DRB Application No.: 05DRB-00712 (SBP)
Project Name: JOURNAL CENTER LOT 10A
Agent: John Klee

DRB Application No.: 05DRB-00711 (SBP)
Project Name: JOURNAL CENTER LOT 10B
Agent: John Kell

**CITY OF ALBUQUERQUE
PLANNING DEPARTMENT
May 11, 2005
DRB Comments**

RE: Lots 10A & 10B, Journal Center/SPBPs

JOB TITLE: JOURNAL CENTER LOT 10B			
REVISION: 05-05-05	FILE NAME	JOB NO.	DATE 03-11-05
SHEET TITLE: ELEVATIONS			DRAWN BY RI

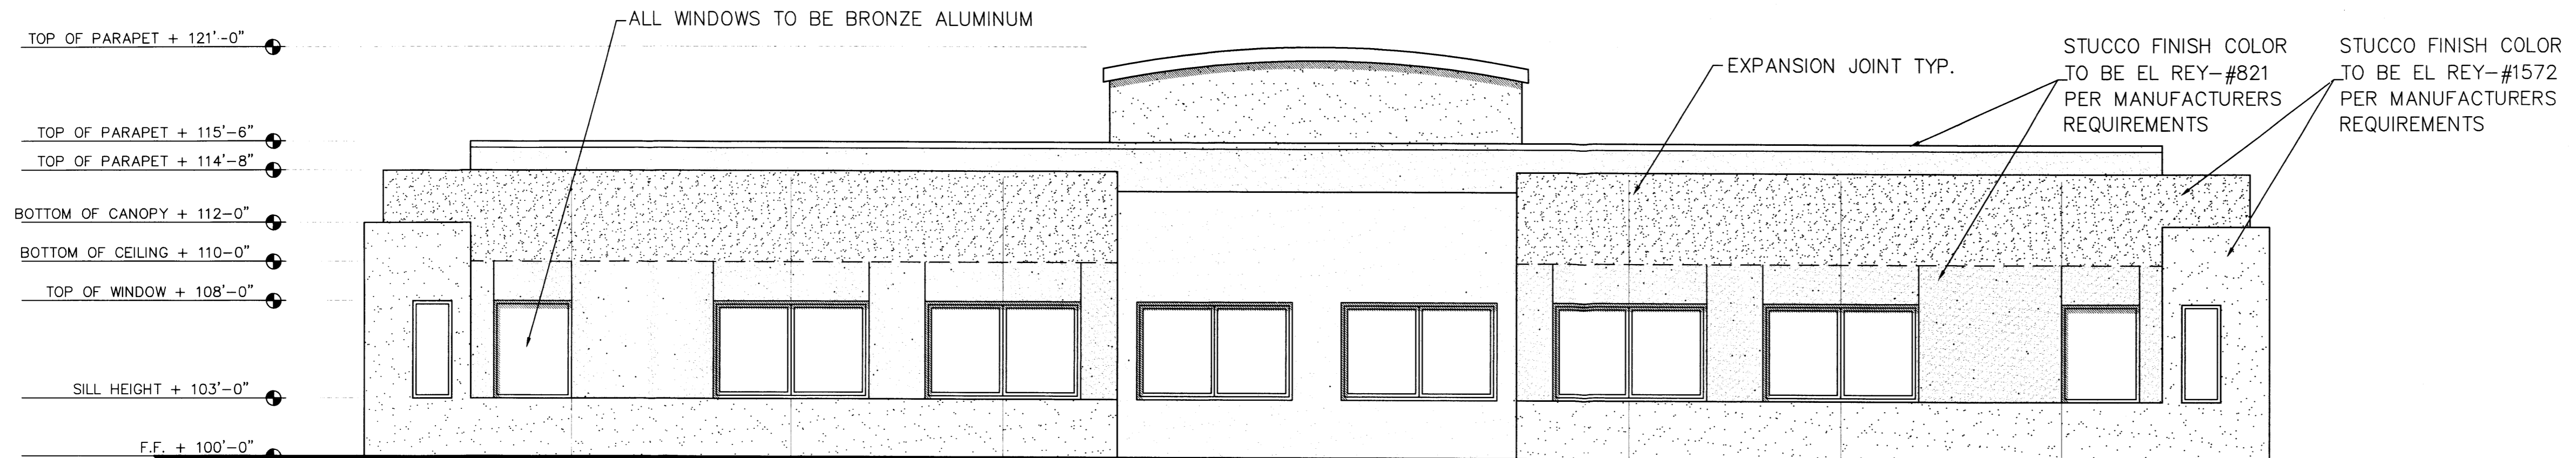
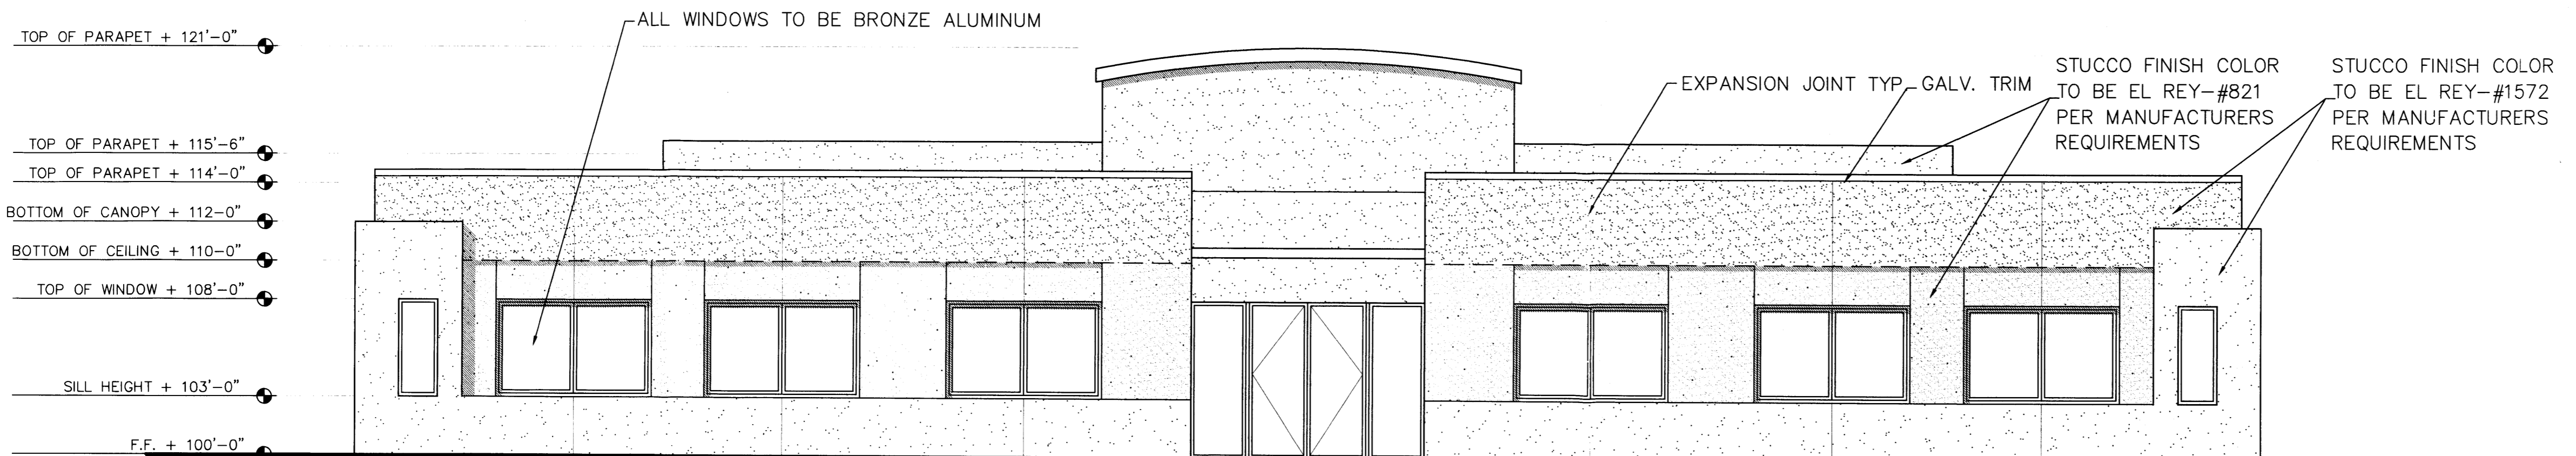
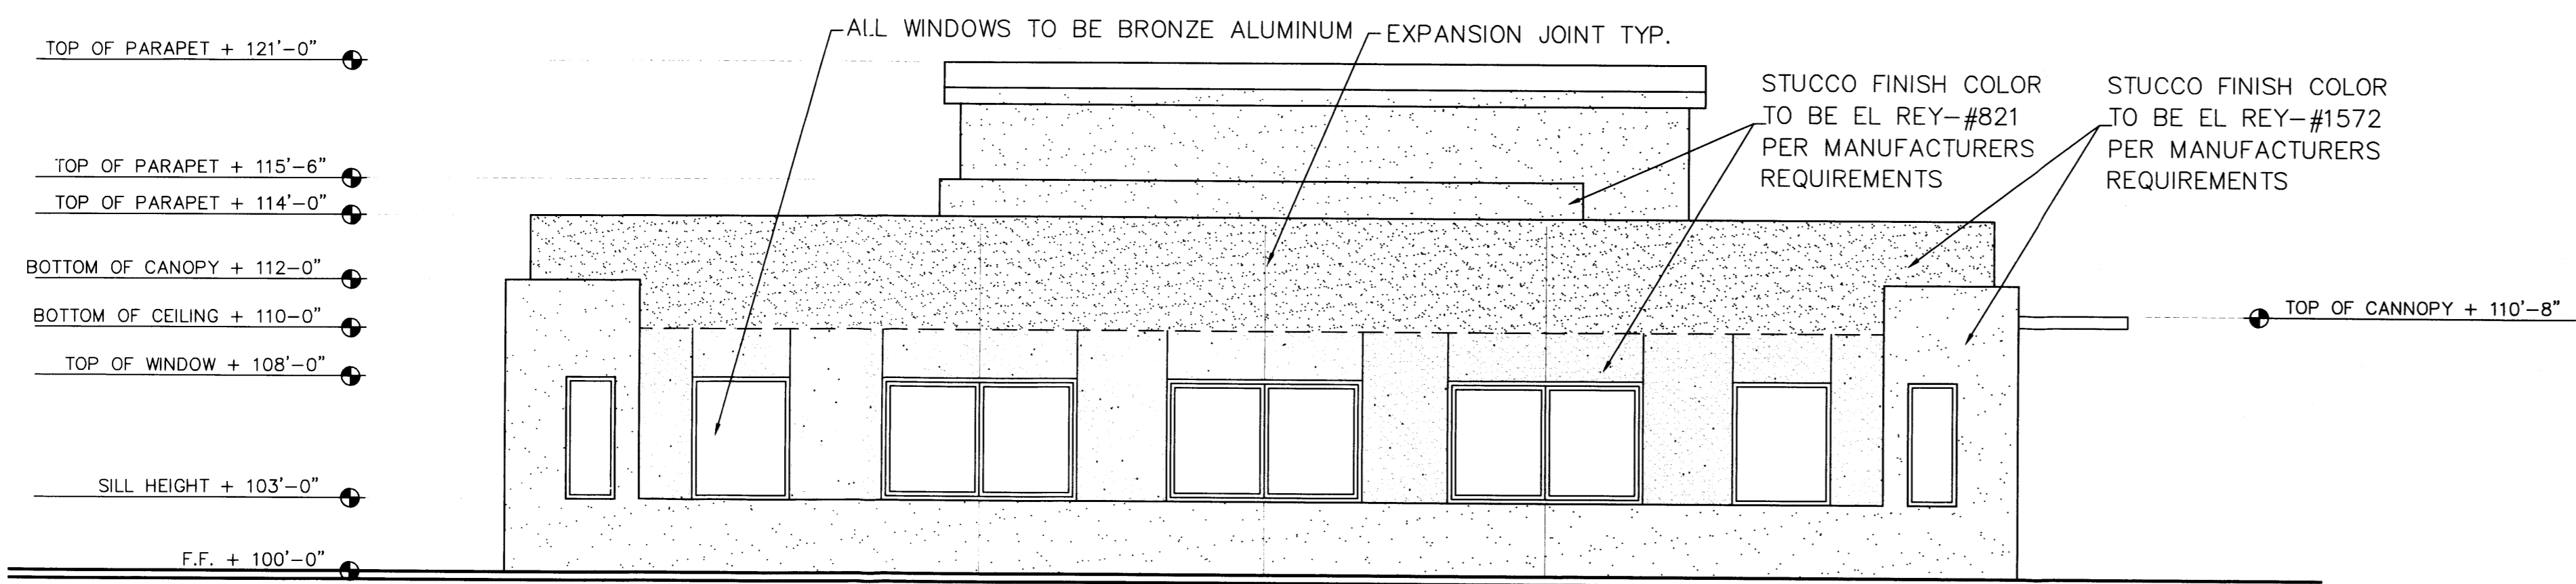
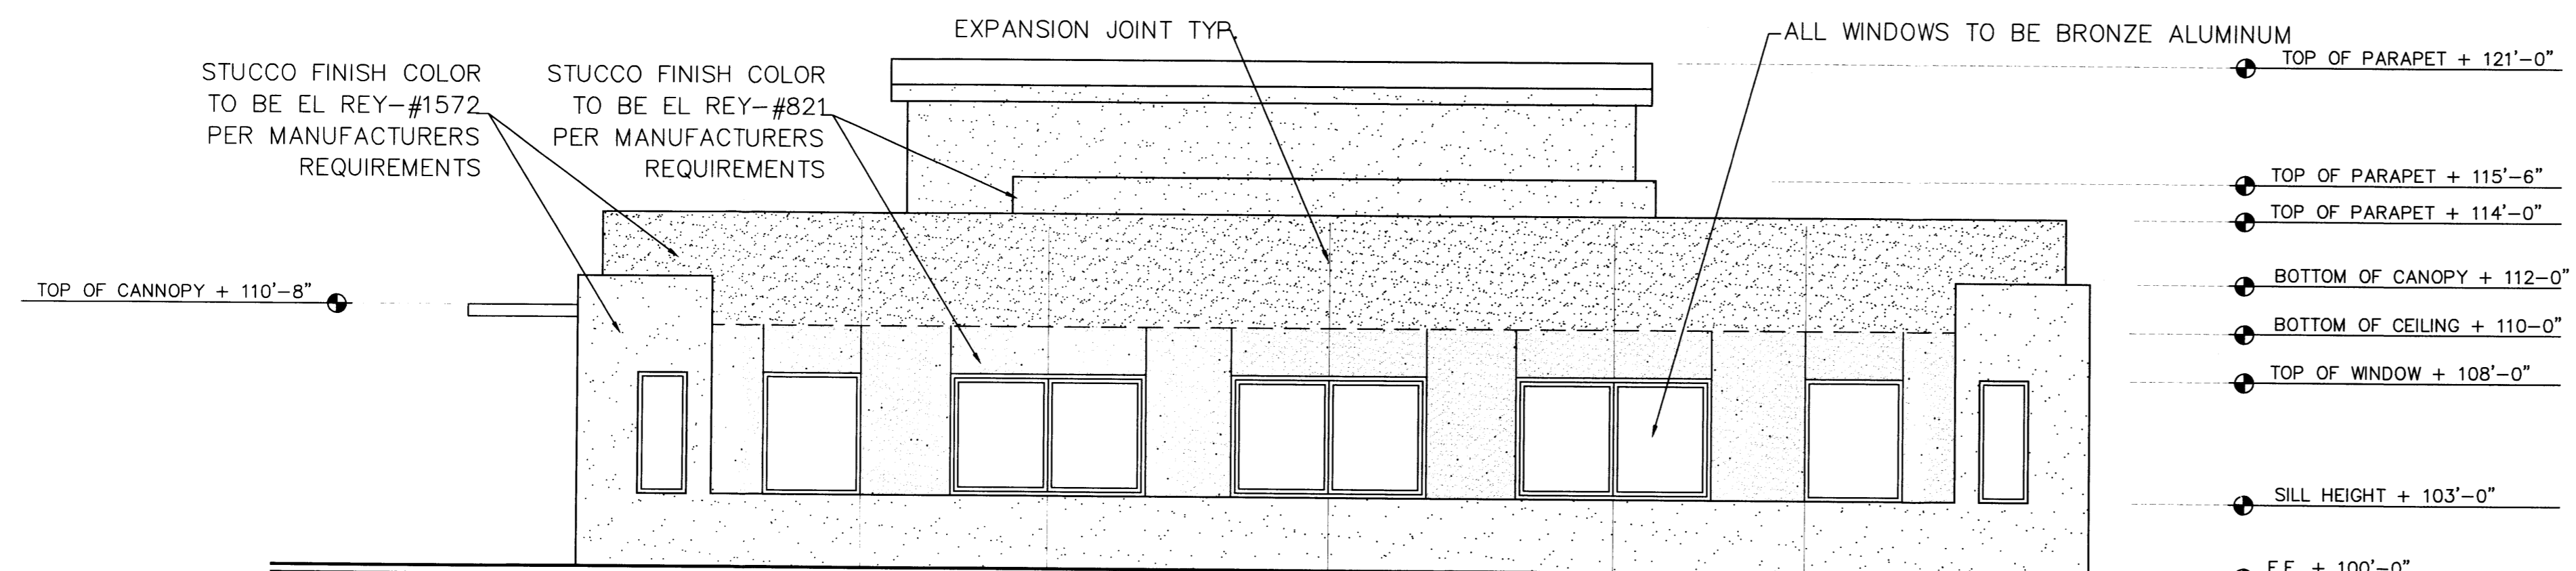
1. The Journal Center ARC approval letters are needed for Planning approval.
2. The property lines are not clearly indicated on the Landscape Plans as required.
3. All of the existing easements are not show on the site plans. For example, the 10' PUE on the plat is missing from both site plans.
- ✓4. Several items on the checklist are neither checked nor marked with an "n/a" and explanation as to why they are "n/a".
5. Easements are missing on the Landscape Plans as well.
6. Location arrows indicating which landscaped area the square footage is for are needed.
7. Overall building width dimensions are missing on the Elevations sheets.

SITE PLAN
SCALE: 1"=10'-0"

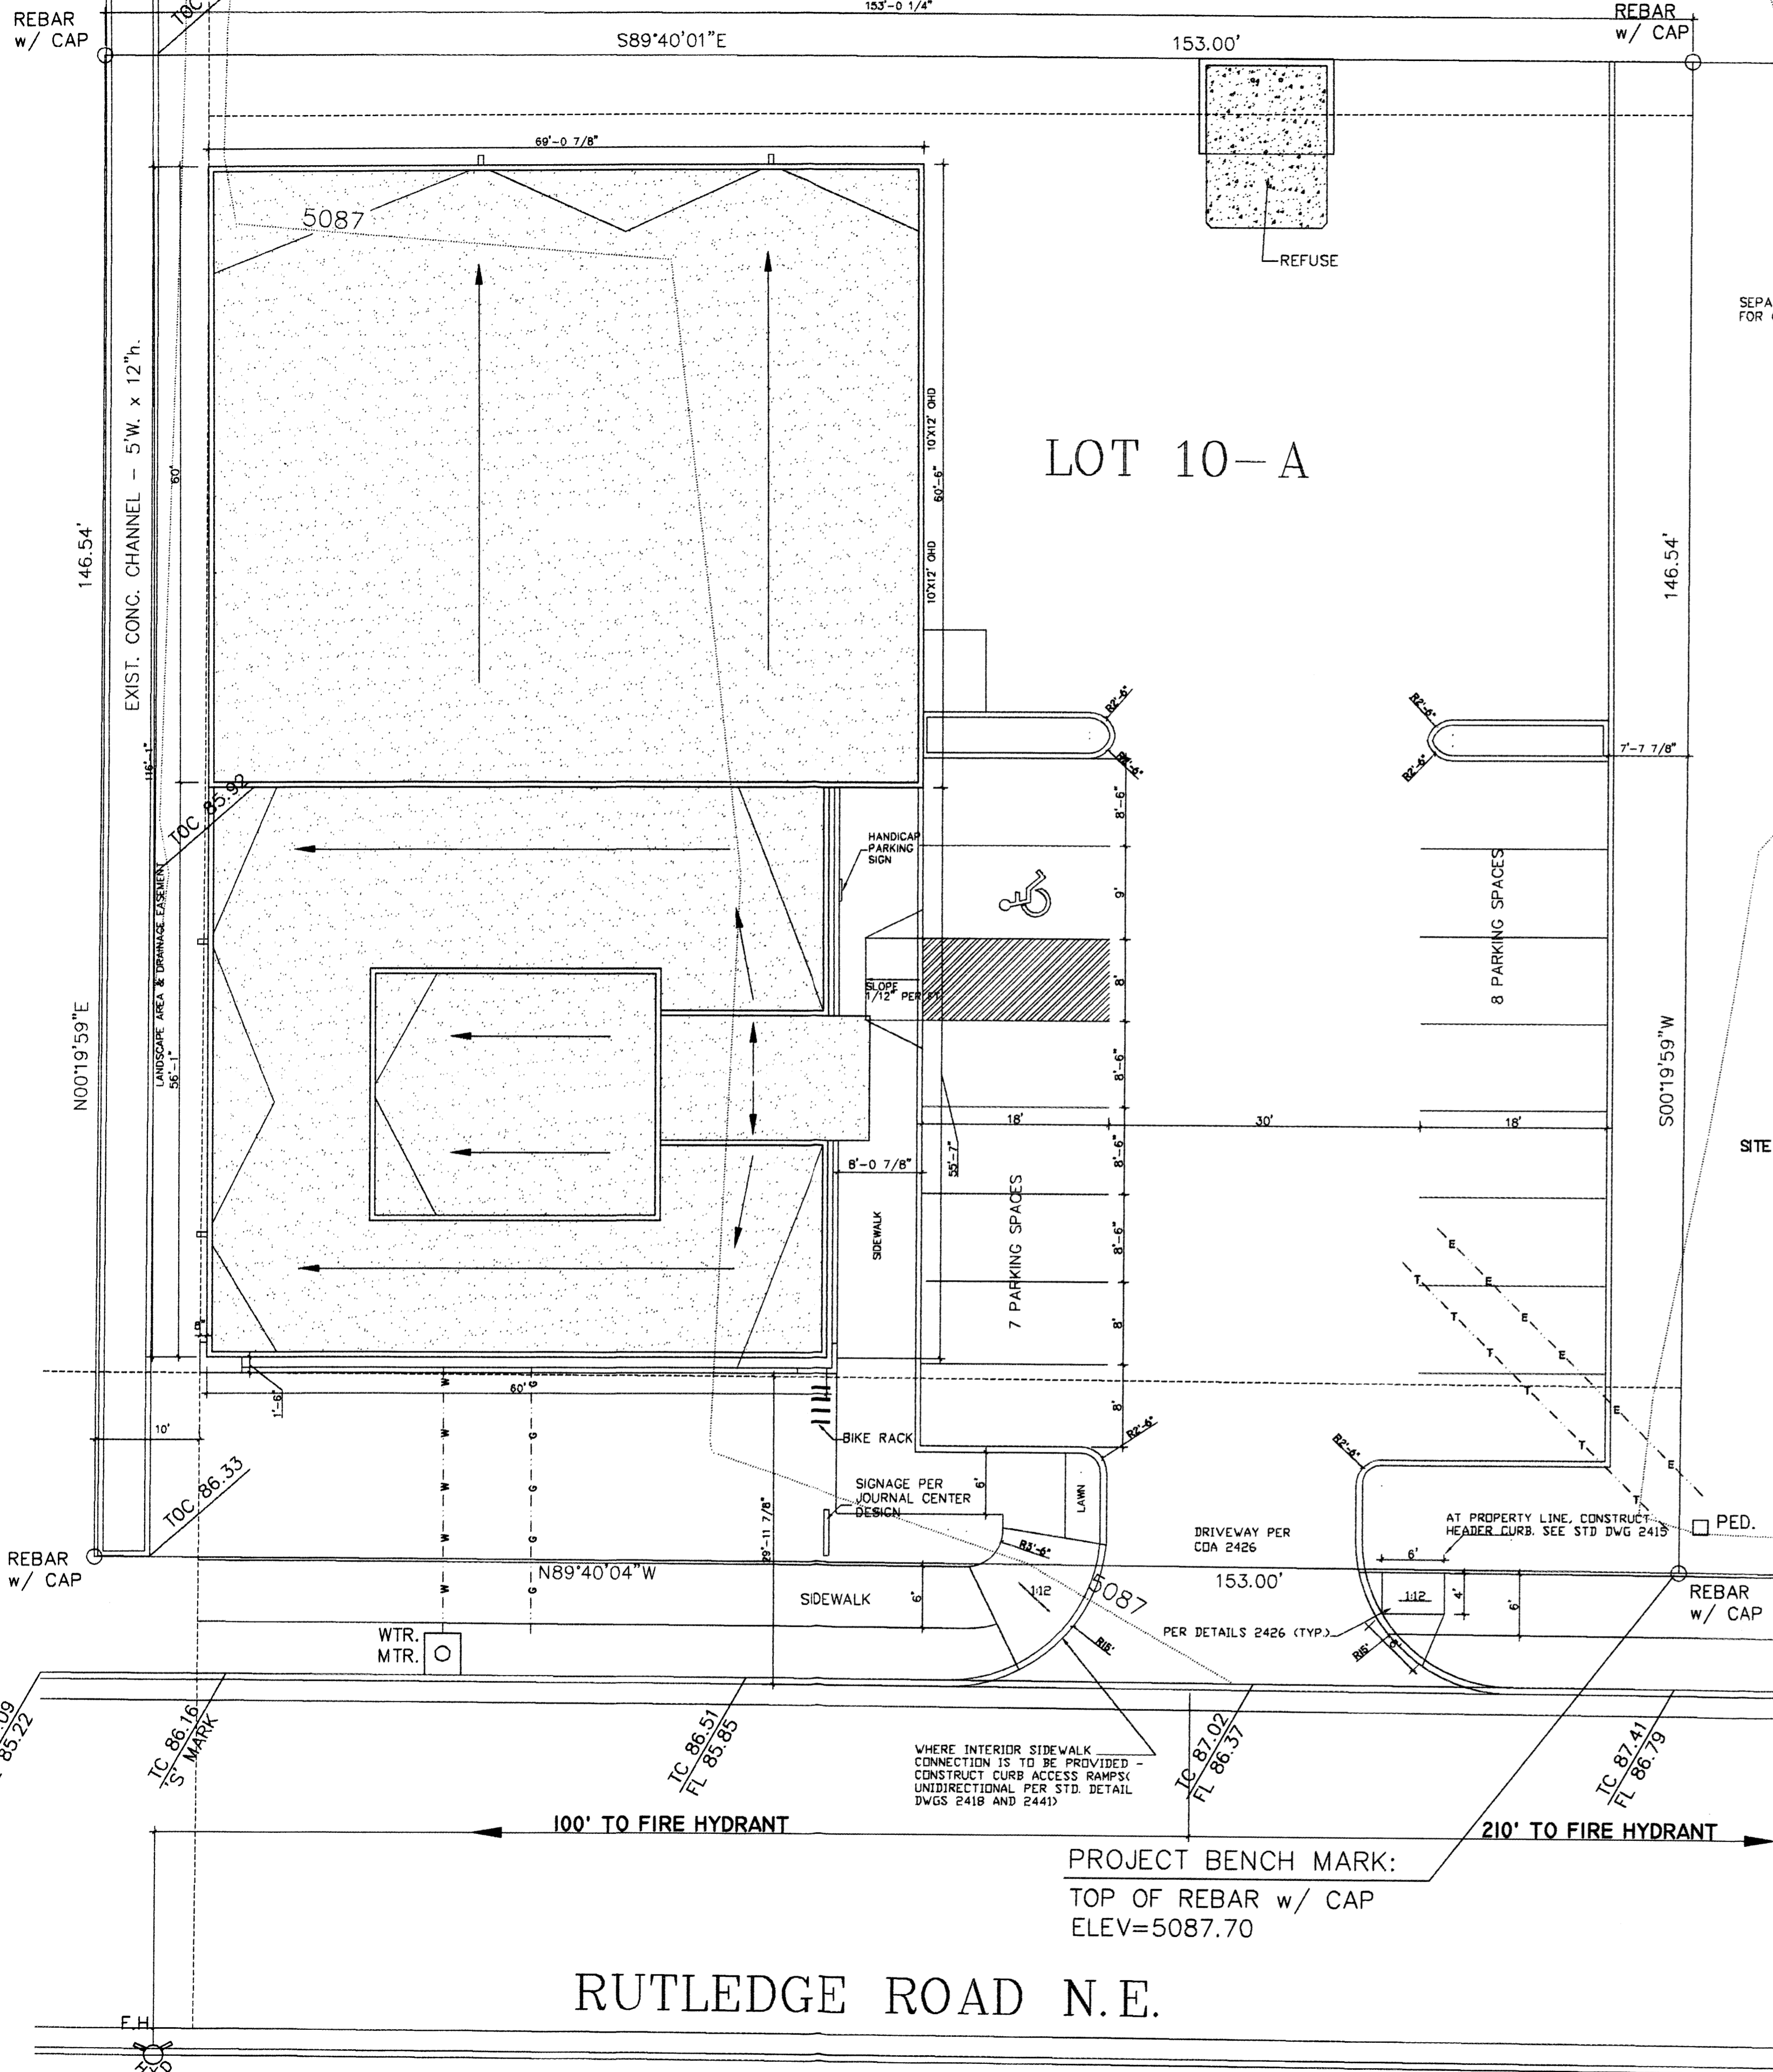
TRANSPORTATION: stall dimensions
alignment of drives ok
sidewalk configuration 6-2-05

TRANSPORTATION: stall dimensions, alignment of drives, sidewalk verification
